Your ref:  
Our ref: 24/00569/F  
Please ask for: Lynn-Marie Elliott  
Direct dial:  
E-mail: borough.planning@west-norfolk.gov.uk

Details: **Garage Conversion and associated works. at 24 Wimbotsham Road Downham Market Norfolk PE38 9PE**

I have received a planning application as detailed above but cannot process it until I receive some more information:

Title :
 GROUND FLOOR PLAN
 AS EXISTING

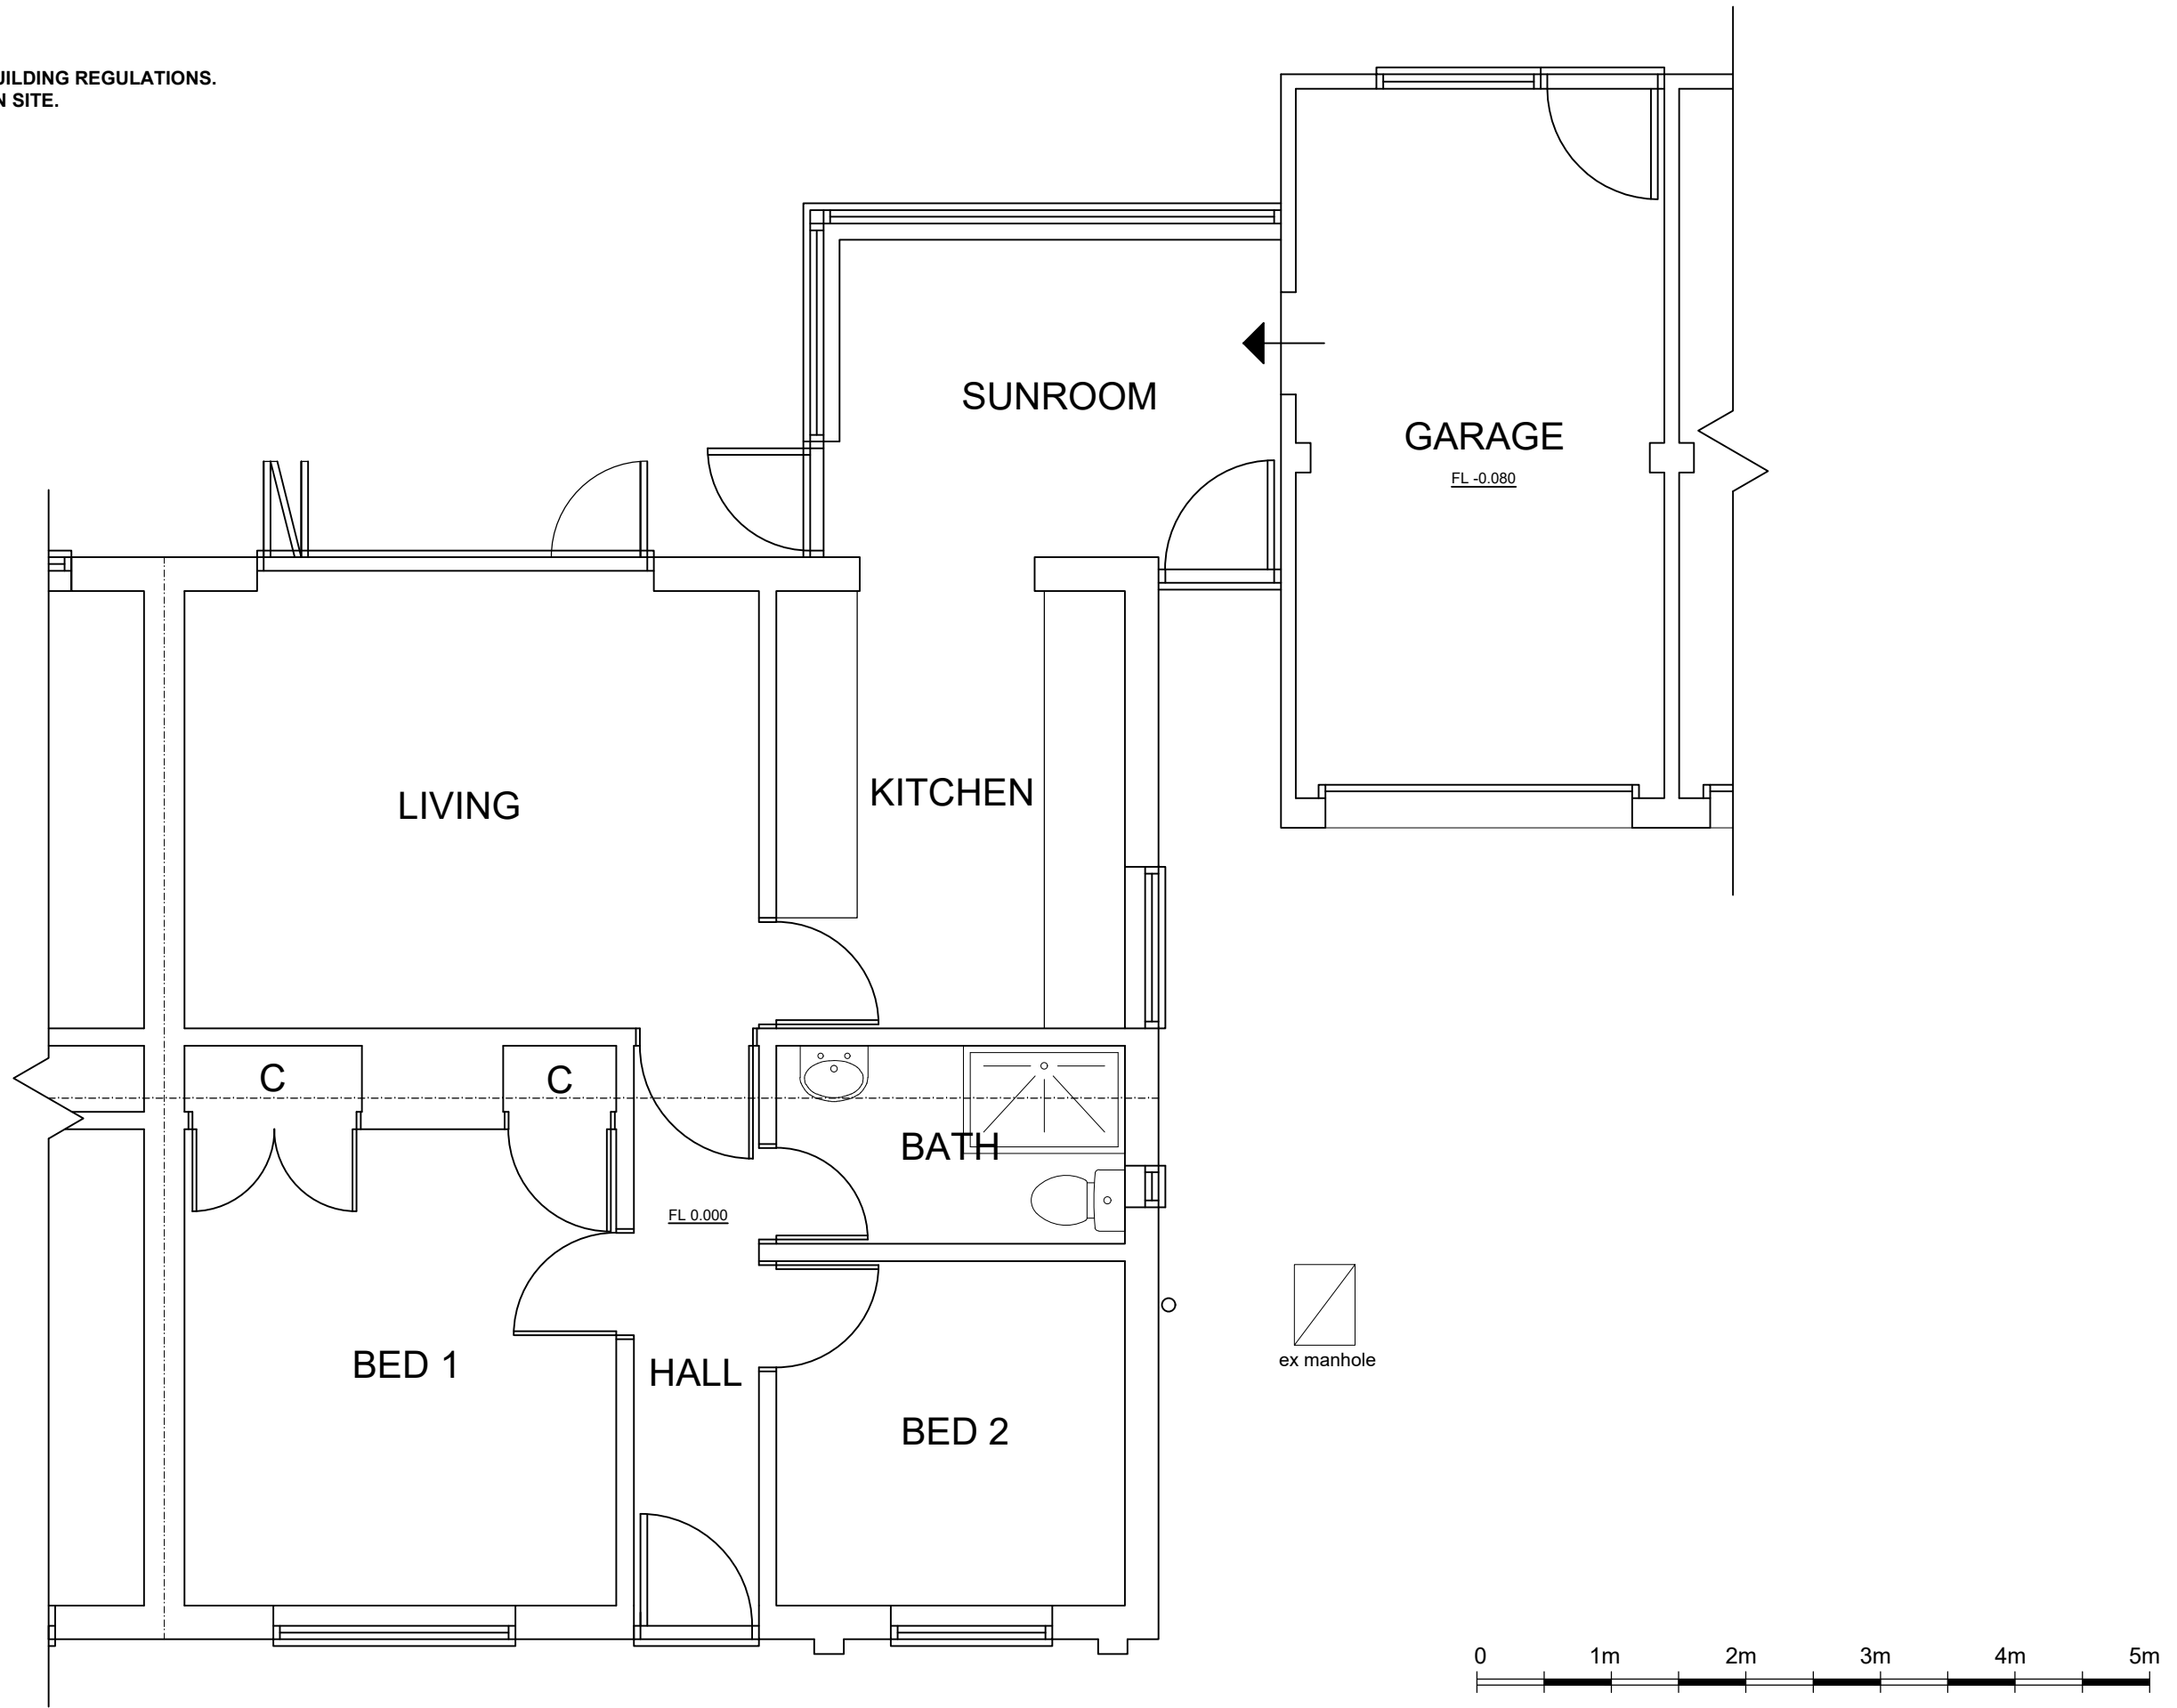
1. Please remove wording 'Do not scale from drawings' from ground floor existing and proposed plans.
